WEST SUSSEX COUNTY COUNCIL CONSULTATION

TO:	Arun District Council FAO:James Cross
FROM:	WSCC - Highways Authority
DATE:	5 February 2020
LOCATION:	Cinders Lane Nursery And Works To The Rear Cinders Lane Yapton BN18 0JJ
SUBJECT:	Y/9/20/DOC Approval of reserved matters following Y/4/19/RES relating to conditions 4-provision of bird & bat boxes, bat tiles & bat bricks; 5-landscape management plan; 6-screen wall & fence details; 7-details of bin stores, sheds & cycle stores; 8-details of children's LAP & LEAP play space.
DATE OF SITE VISIT:	n/a
RECOMMENDATION:	Advice
S106 CONTRIBUTION TOTAL:	n/a / £ See below for breakdown.

Drawing No : DT_EXT_652

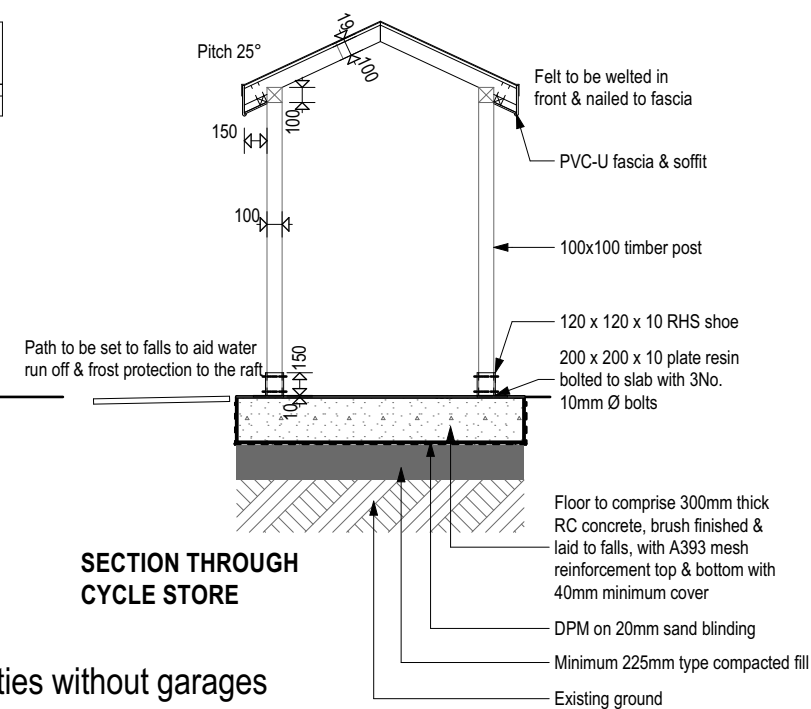
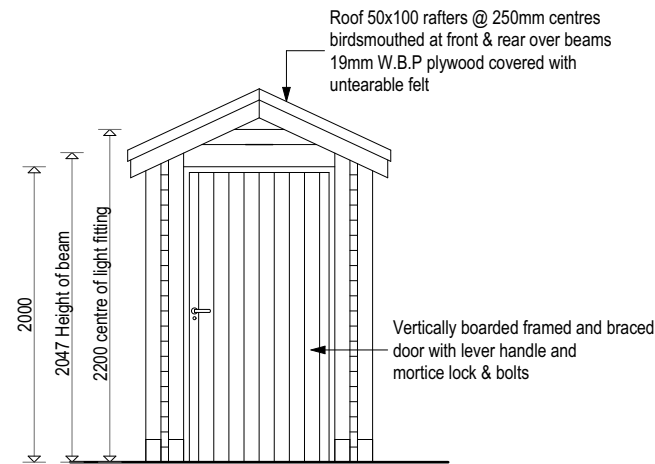
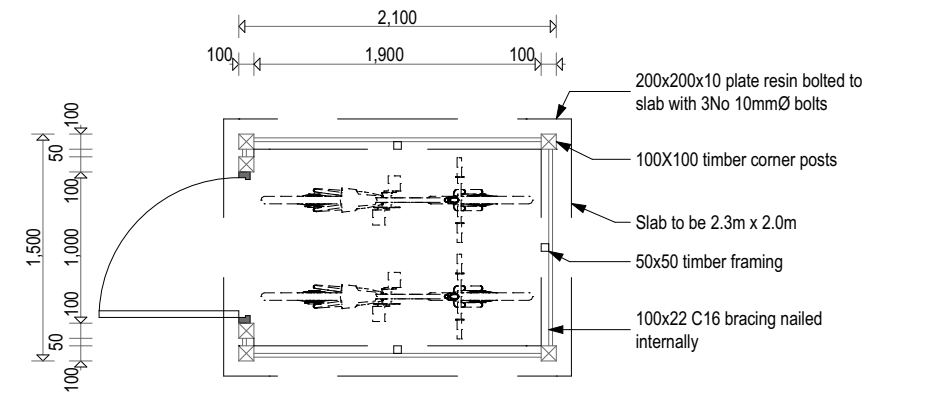
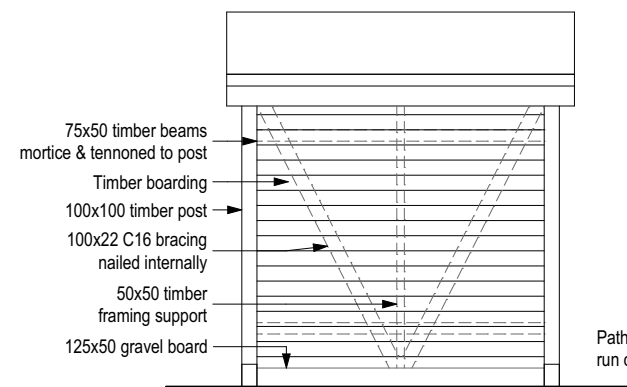
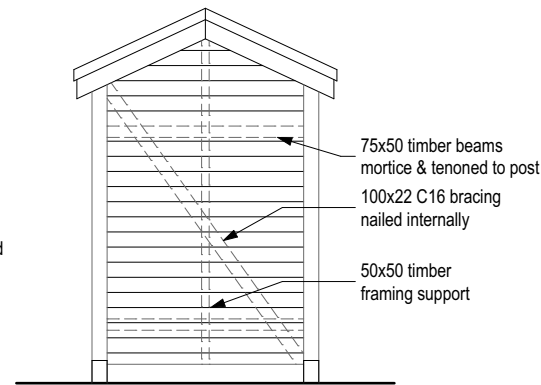
For the purposes of this application Condition 7 is most relevant to highway matters. The LHA has reviewed information submitted on the planning portal, namely drawing number DT_EXT_652 which demonstrates cycle parking within secure and covered sheds. The LHA would be satisfied that condition 7 can be discharged.
